4 August 2017

MP10_0044_MOD 2

SECTION 75W MODIFICATION TO BUILDING D, MONTEFIORE SITE RANDWICK

DRAWING TITLE
BLOCK D ELEVATIONS

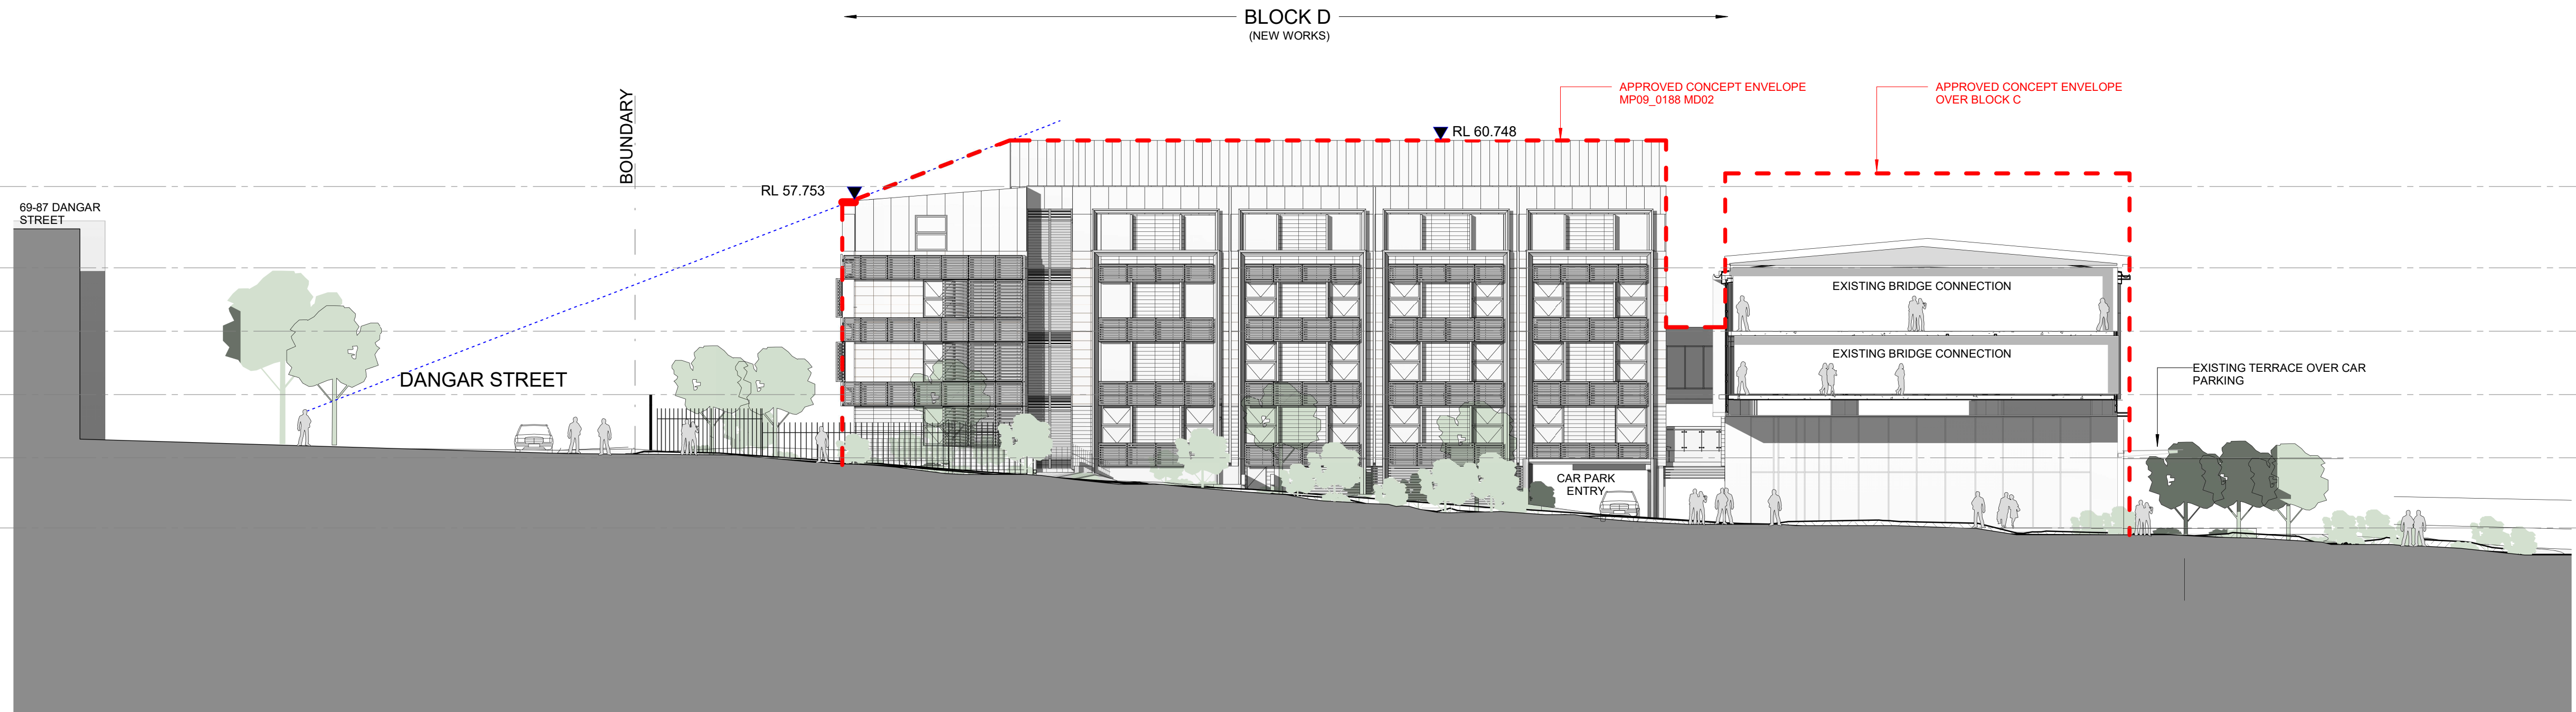
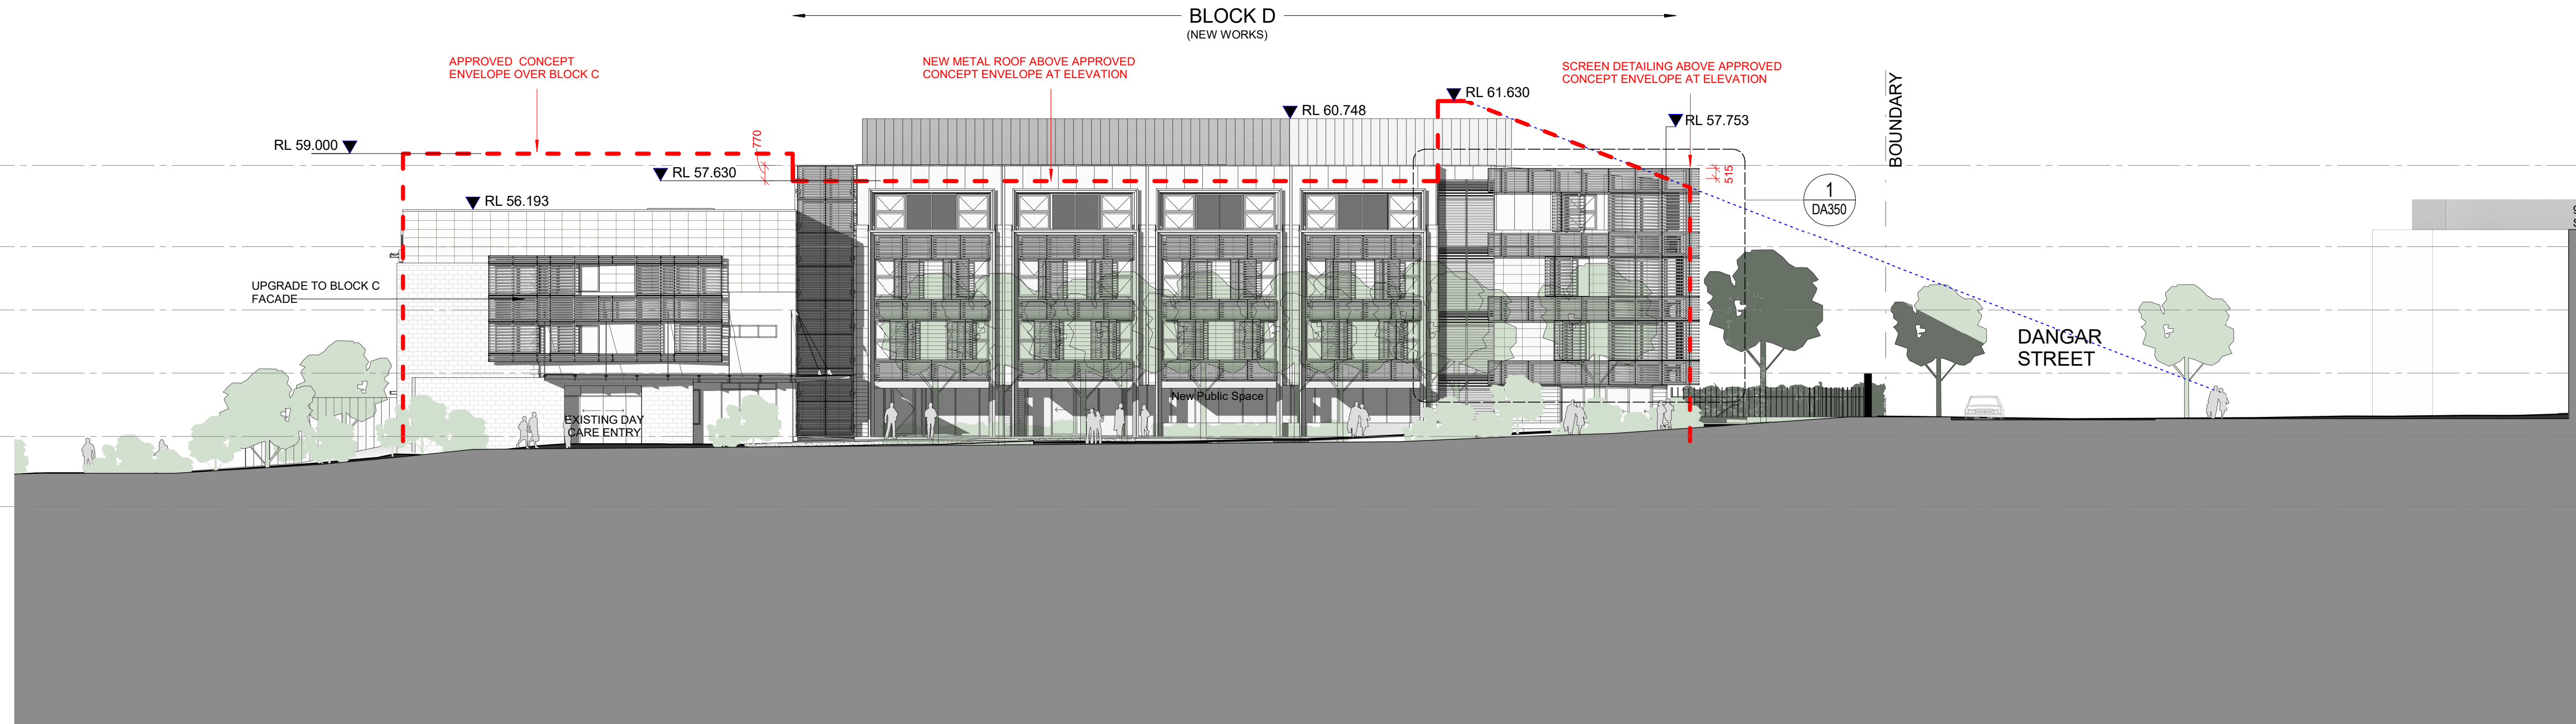
2.2.1. The 770mm 'parapet protrusion' along King Street:

- We note the protrusion is 770mm at the King Street and return parapets (ie worse case) with the metal roof raking down to the north, to a much lesser degree (refer to the King Street elevation and Section 1 extract in Figures 1 and 2 below).

- As a consequence of the removal of these dementia care rooms, the roof-top terrace for these residents became redundant, and hence needed to be replaced with a metal roof structure with appropriate fall for drainage and street-front parapet. Therefore, in order to meet the new function of this redundant roof-top space (caused by the condition) a small increase to the building envelope on this part of the roof needs to be accommodated.

- It is noted that this height does not exceed the total approved building height established by the roof plant of Level 7 and is contained below the approved height of Building C, and well below the overall approved height of Building E. Consequently, this minor protrusion of this part of the roof of Building D has no consequence in relation to view loss from those properties on the eastern side of Dangar Street looking west or north-west, nor buildings on the southern side of King Street (given the results of the visual impact assessment previously conducted as part of the Mod 2 process, and endorsed by the DPE and PAC).

1 EAST ELEVATION
1 : 200

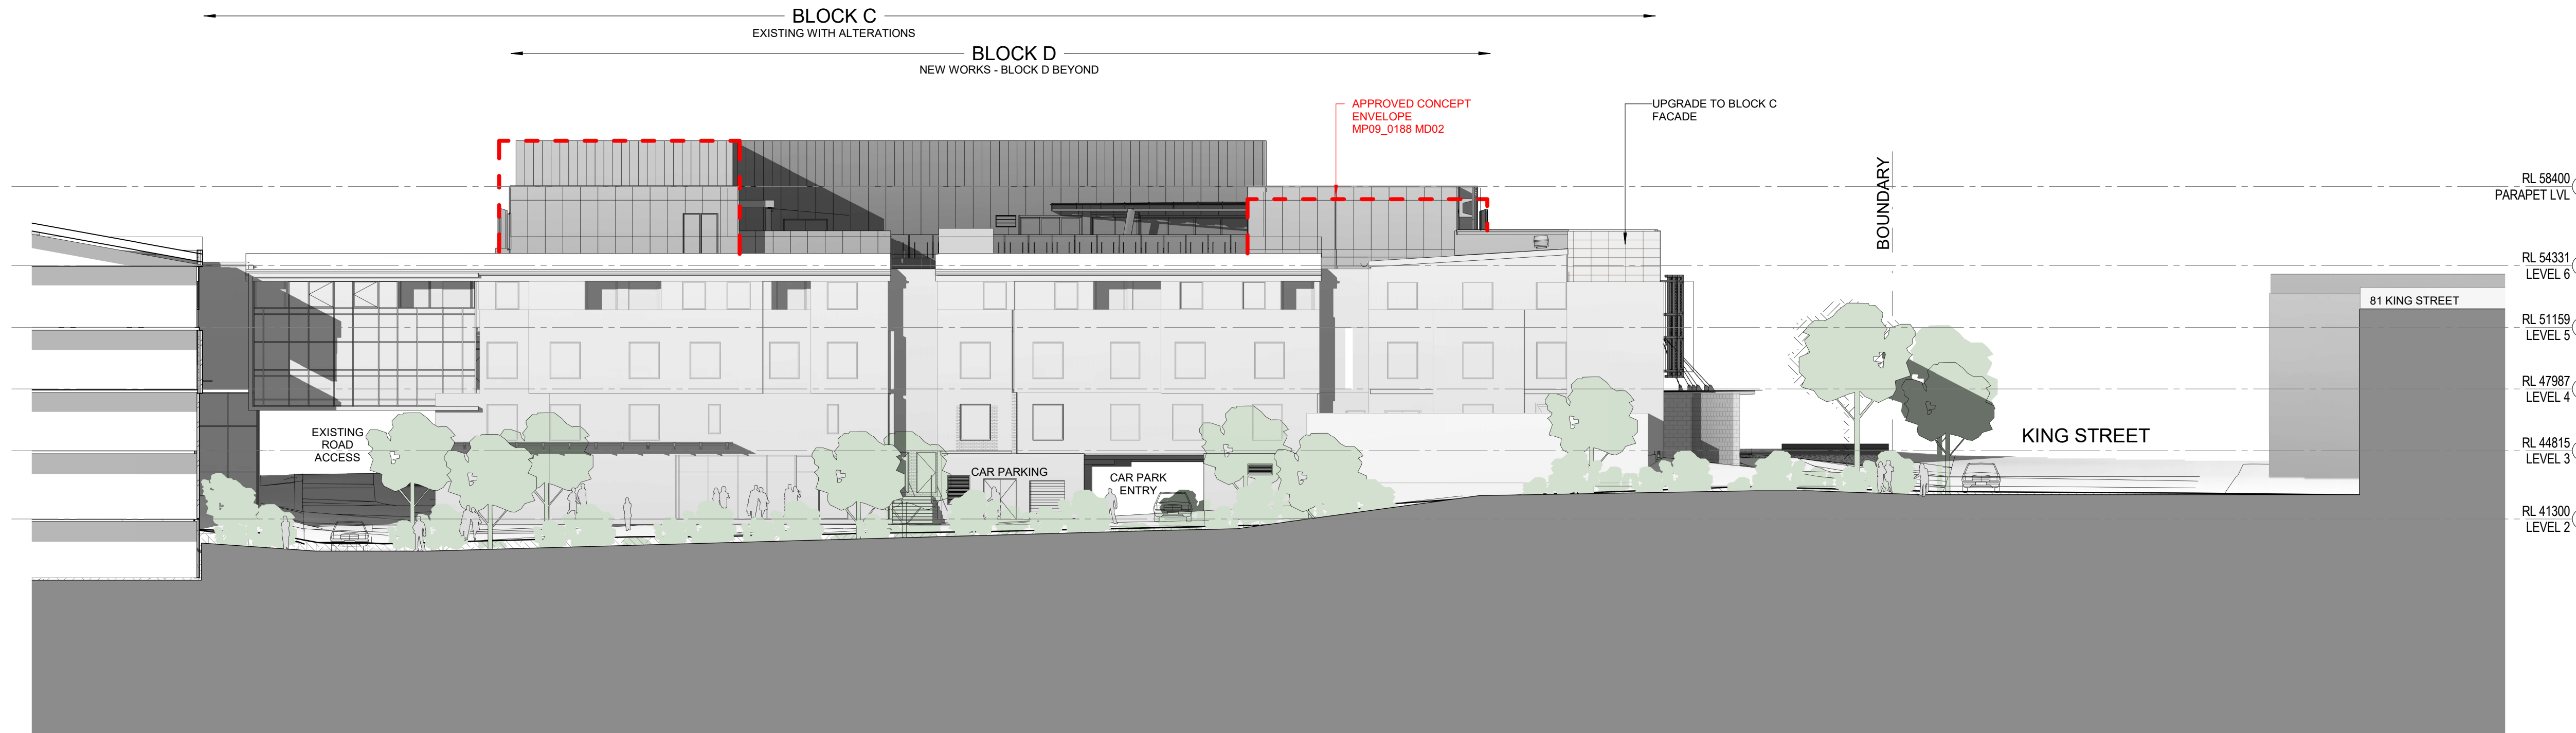
2.2.2. The 515mm 'façade screen protrusion' along Dangar Street:

- This minor protrusion is located at the south-east corner of Building D. As identified in our Planning Report accompanying the subject modification, this element is a light-weight, transparent batten structure that is attached, but that sits proud of the building elevation. It seeks to provide visual interest to an important corner of the building marking the proposed public open space and street corner (refer to the King Street elevation and King/Dangar Street corner perspective in Figures 3 and 4 below).

- The minor degree of intrusion above the building envelope at this corner of the building is well below the overall envelope height of Building D, below the overall envelope height of Building C, and well below the overall envelope height of Building E. Furthermore, it extends for less than 1/3rd of the building's frontage to Dangar Street.

- The combination of the facts above, means this minor façade edge protrusion to the building's south-eastern corner has no impact on views compared to that previously assessed and approved as part of the Concept Plan Mod 2, granted by the PAC. Nor does it have any material visual impact when viewed from pedestrians walking along Dangar Street.
